Comment for planning application 21/03350/TEL

Application Number	21/03350/TEL
Location	Street Record Station Road Kirtlington
Proposal	Proposed 5G Telecommunications Installation
Case Officer	John Cosgrove

Organisation Name	Sophie and Ed Macfarlane
Address	Windover, Station Road, Kirtlington, Kidlington, OX5 3HE
Type of Comment	Objection
Type	neighbour

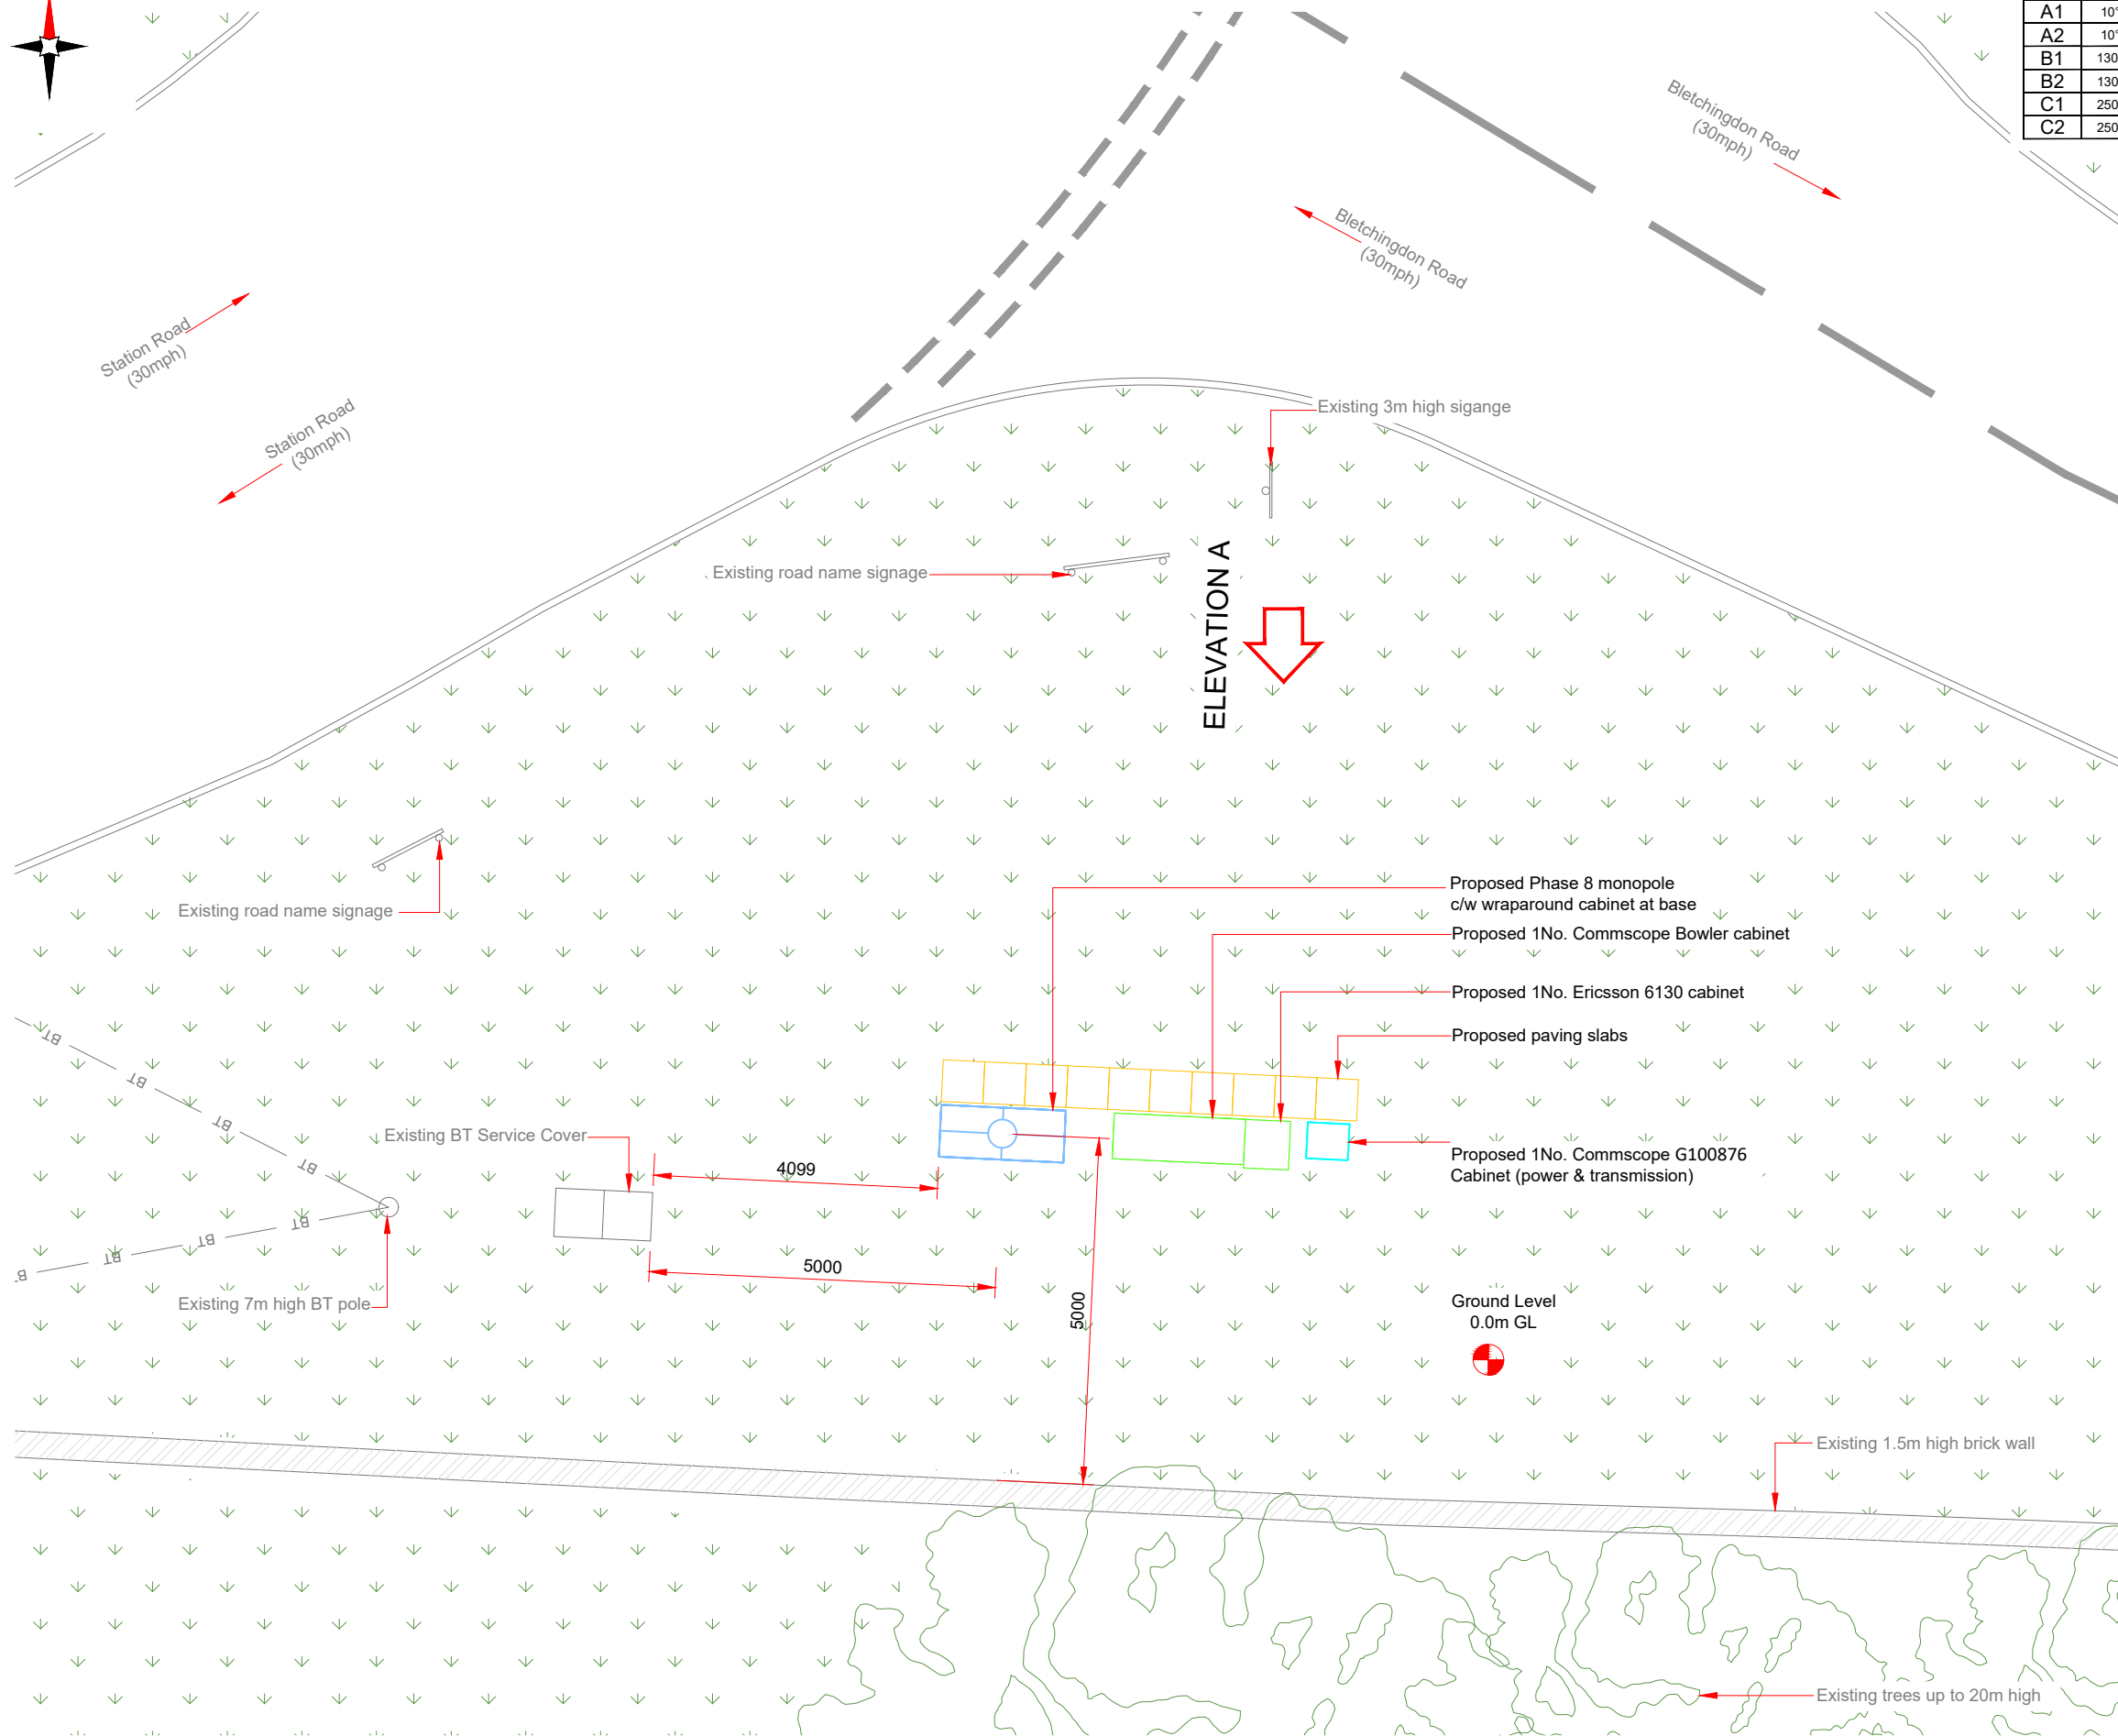
density and negligible mobile business, decent 4G/3G coverage and excellent broadband? <https://www.ispreview.co.uk/index.php/2021/08/three-uk-sees-5g-mobile-broadband-coverage-reach-29-percent.html> Overall we are astounded at the misleading nature of this planning application, in its plan drawings (of existing and proposed) including lack of details both in what the mast will look like bar a misleading drawing against a non-existent tree, and photography that shows very little of the actual area - including NONE of the surrounding houses who will be in direct line of the mast. The half term objection deadline is also very inconvenient to those who want to object. The very fact no one knew about it or was contacted officially suggests the proposers are trying to get it through under radar. Overall we fully object to the above planning application. Yours faithfully Sophie and Ed Macfarlane
